State of Washington
DEPARTMENT OF FISH AND WILDLIFE

April 15, 2022

SUBJECT: WDFW COMMENTS ON LP-22-00002 MOHAR FARM CLUSTER PLAT

PRELIMINARY MOHAR FARM CLUSTER PLAT

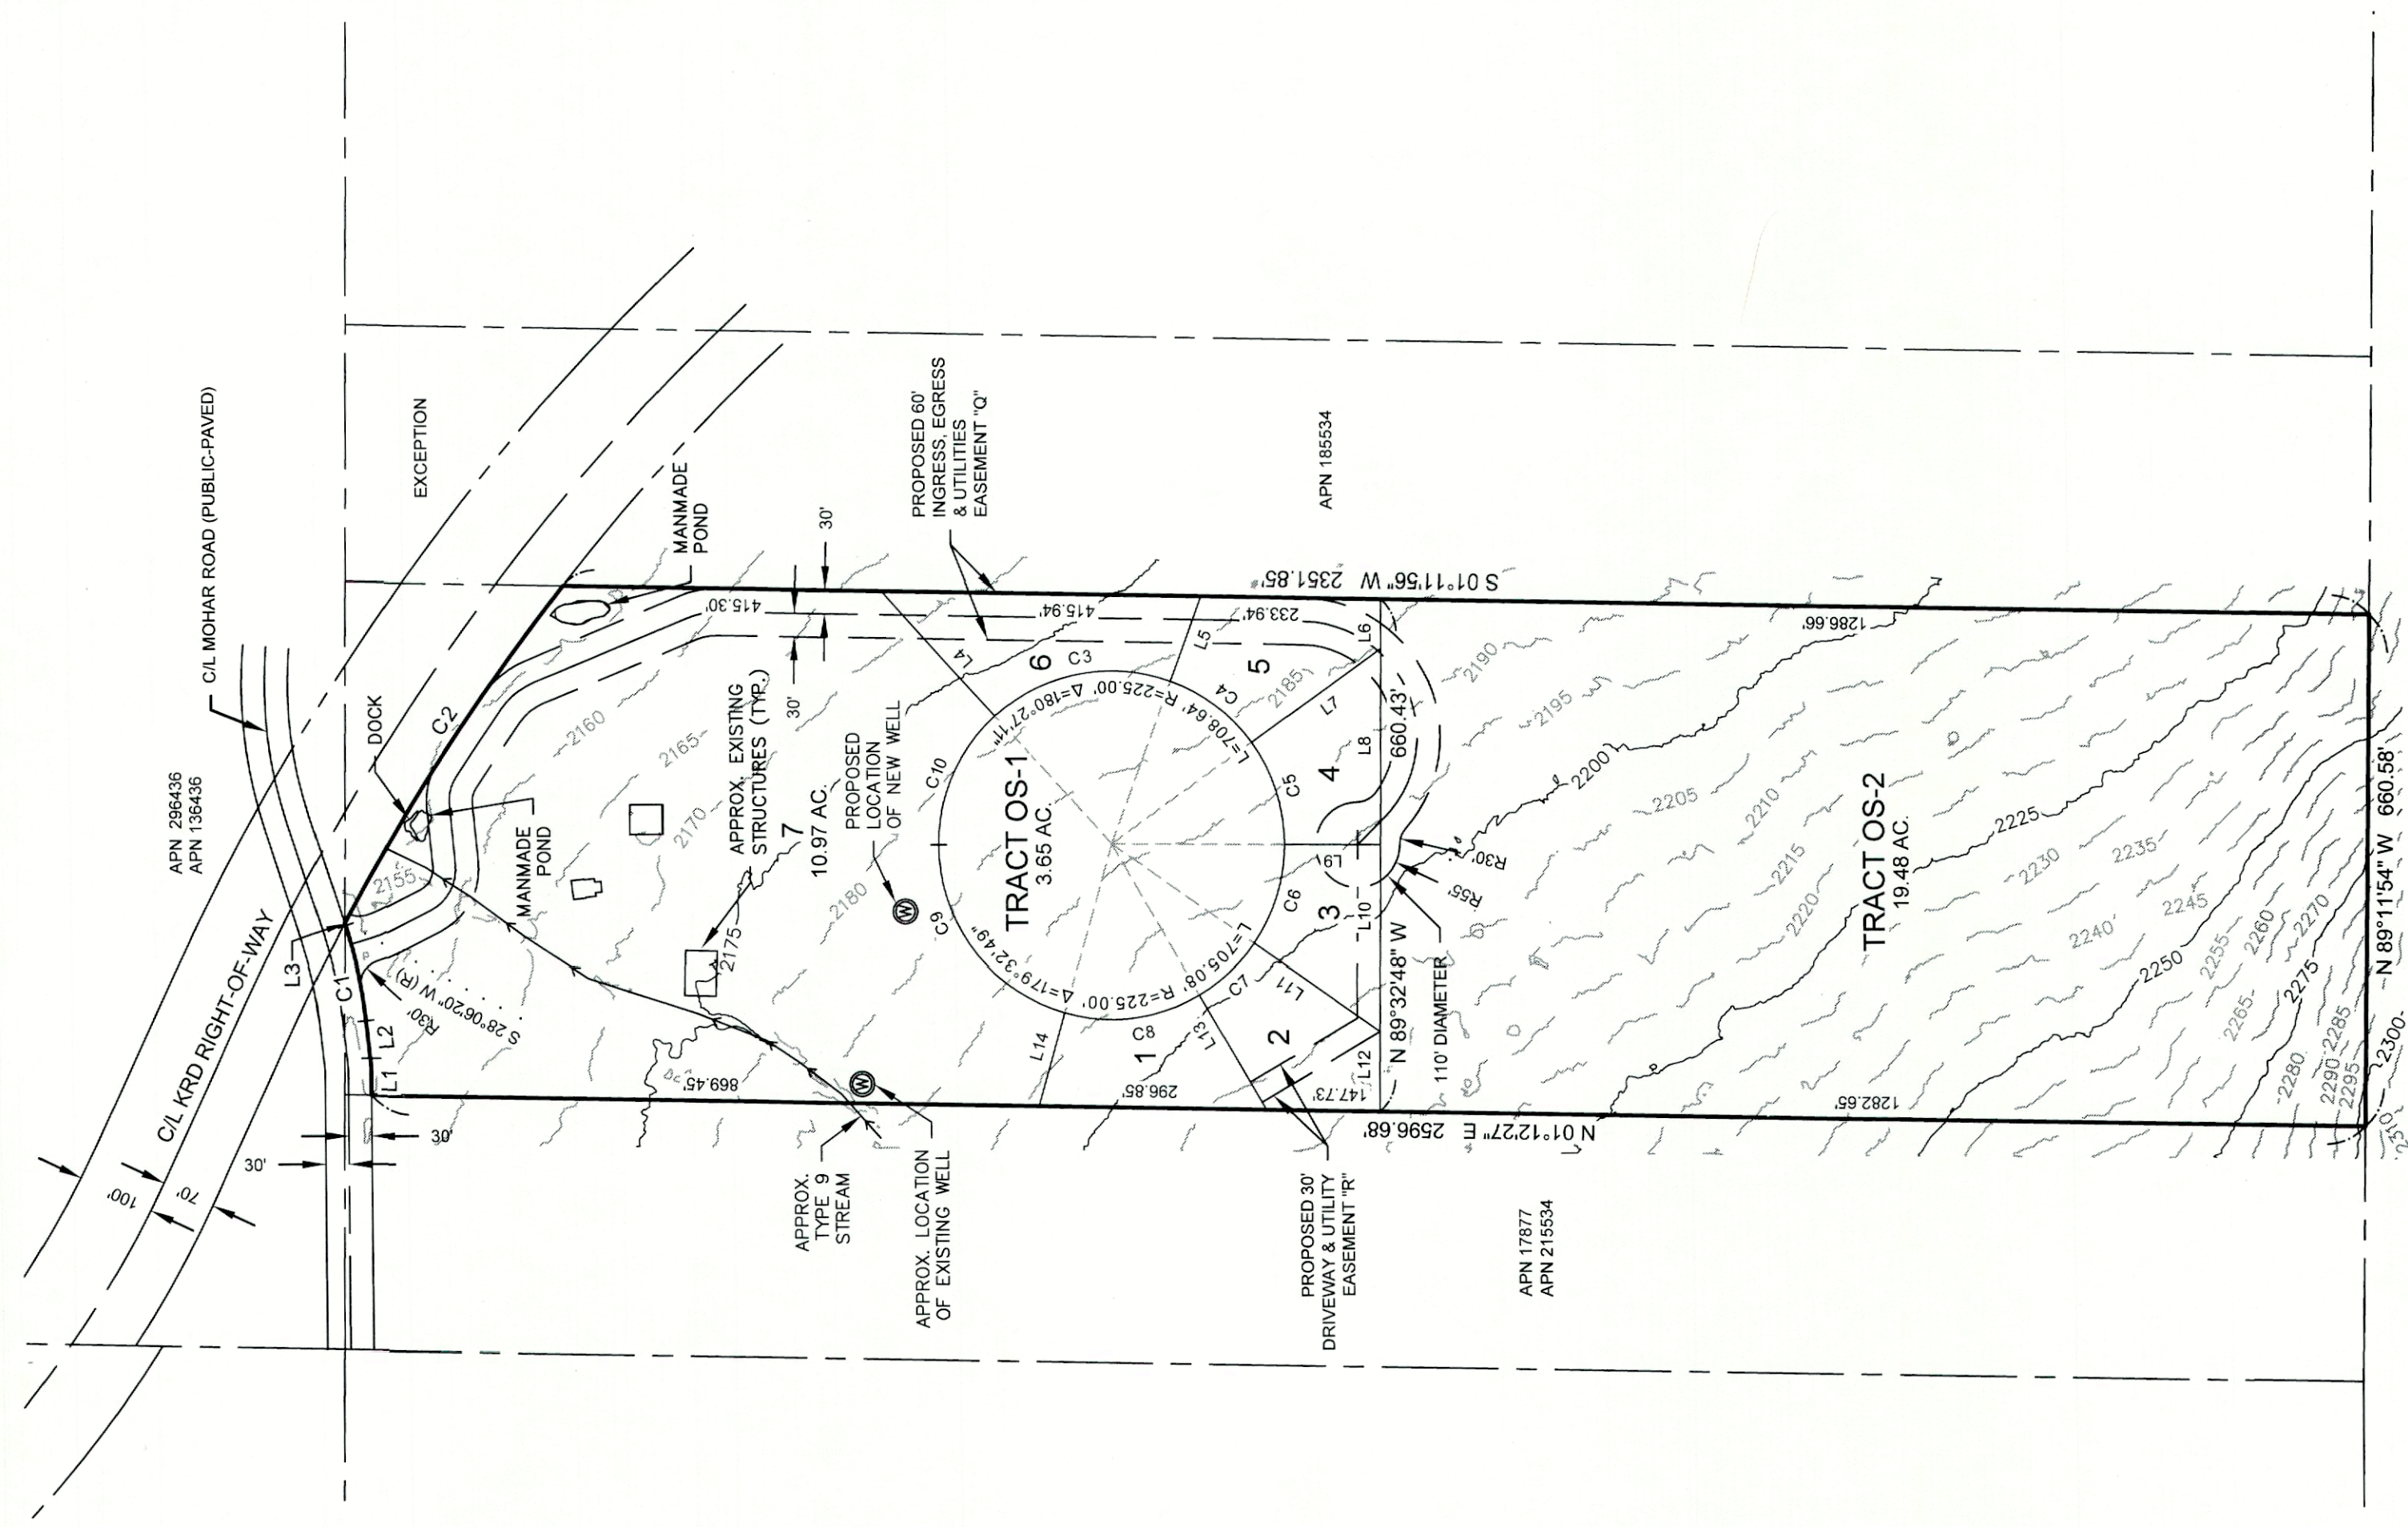
We have not had the opportunity to survey the stream mapped on this property but anticipate road improvements necessary to provide access to the new lots will require a new water crossing structure and likely a Hydraulic Project Approval permit from WDFW. Prior to any grading and/or improvements to the driveway at the stream crossing, we recommend a site visit with WDFW to assess conditions and whether an HPA is required for the work.
